Re planning application R/190/13/1

I should like to state my objection to planning application R/190/13/1 concerning the proposal to erect a three bedroomed house on land to the rear of 20 and 22 Broadmark Lane.

DRAWING TITLE
SITE LOCATION AND LAYOUT PLANS

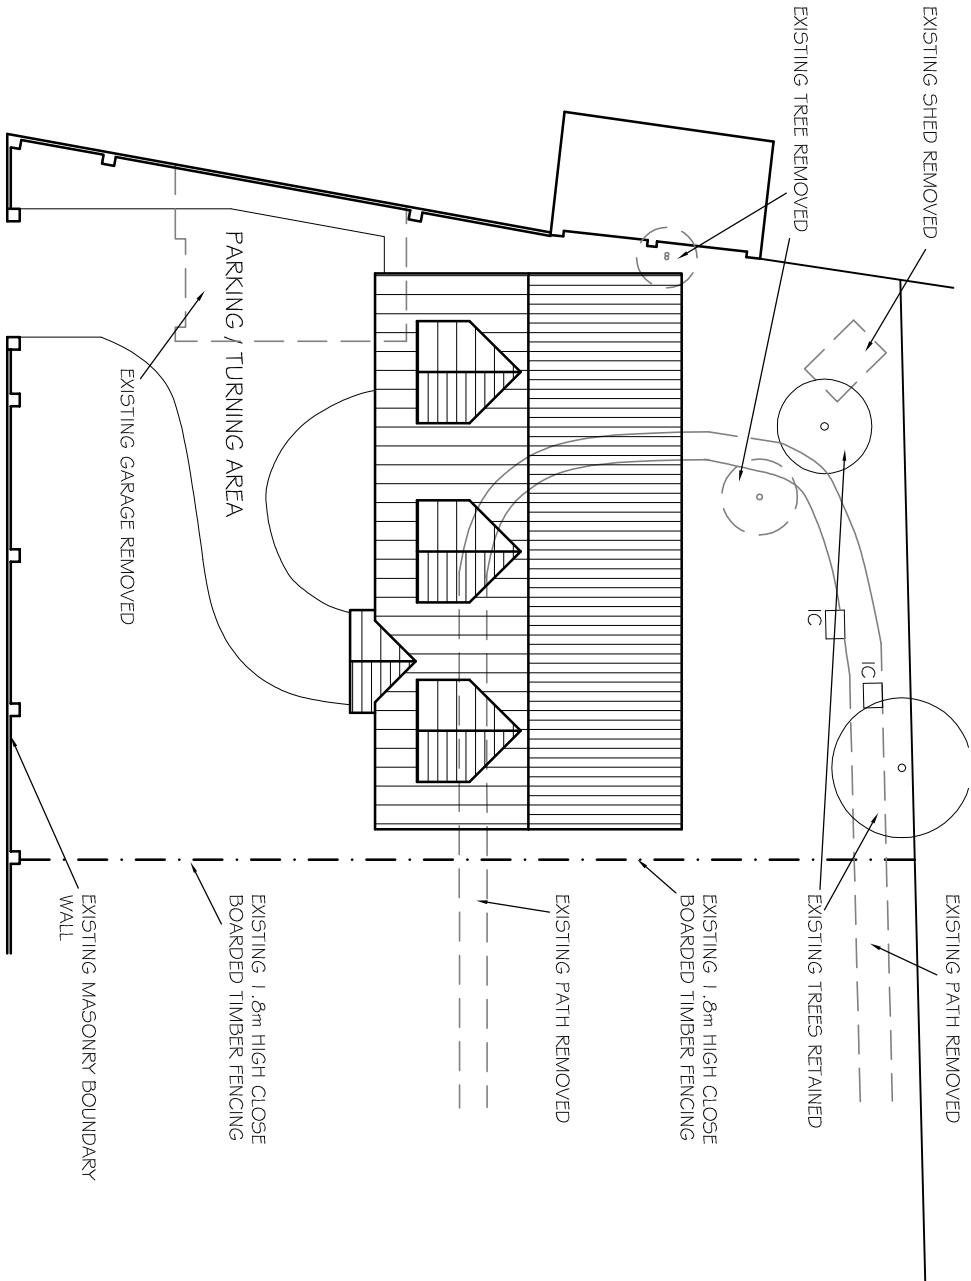
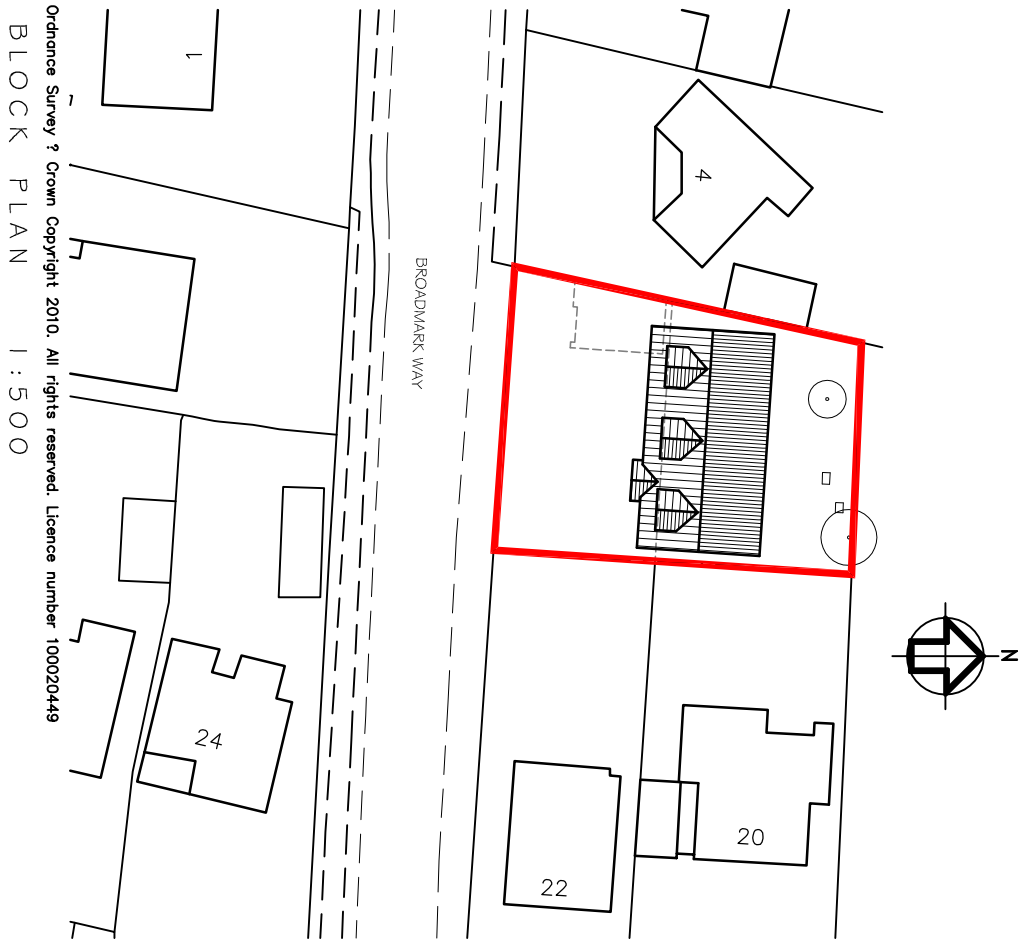
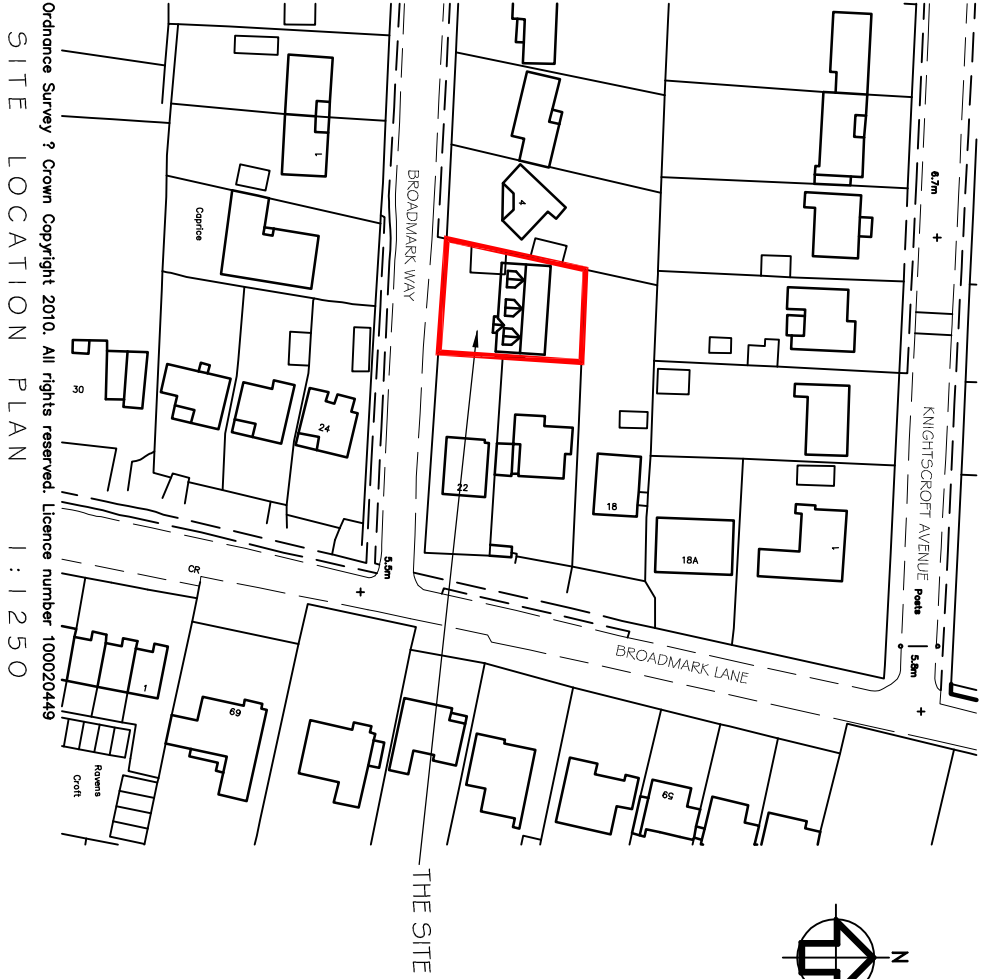
A previous planning application in March 2010 (ref: R/48/10/) was turned down due to its "unduly cramped and contrived form of development which would be detrimental to the character and amenities of the surrounding residential area". It seems to me that, notwithstanding the addition of another chunk of garden (in this case formerly belonging to 20 Broadmark Lane), that this present planning application merits the same judgment. It is a contrived form of development, no less cramped in that it presents you with a building footprint some 60 % larger than the one you rejected in 2010.

- Policy GEN7 (iv) states that is allowed providing it **"does not have an unacceptable adverse impact on adjoining occupiers"**. This is clearly not the case with an excessively large development, more adjacent to 4 Broadmark Way than hitherto proposed, and one whose shadow will reduce the light available to the gardens of 18 and 20 Broadmark Lane, let alone the oppressive presence for all three.
- Policy GEN7 (v) demands that new development **"takes account of any unacceptable adverse impacts"** but this application simply ignores them.
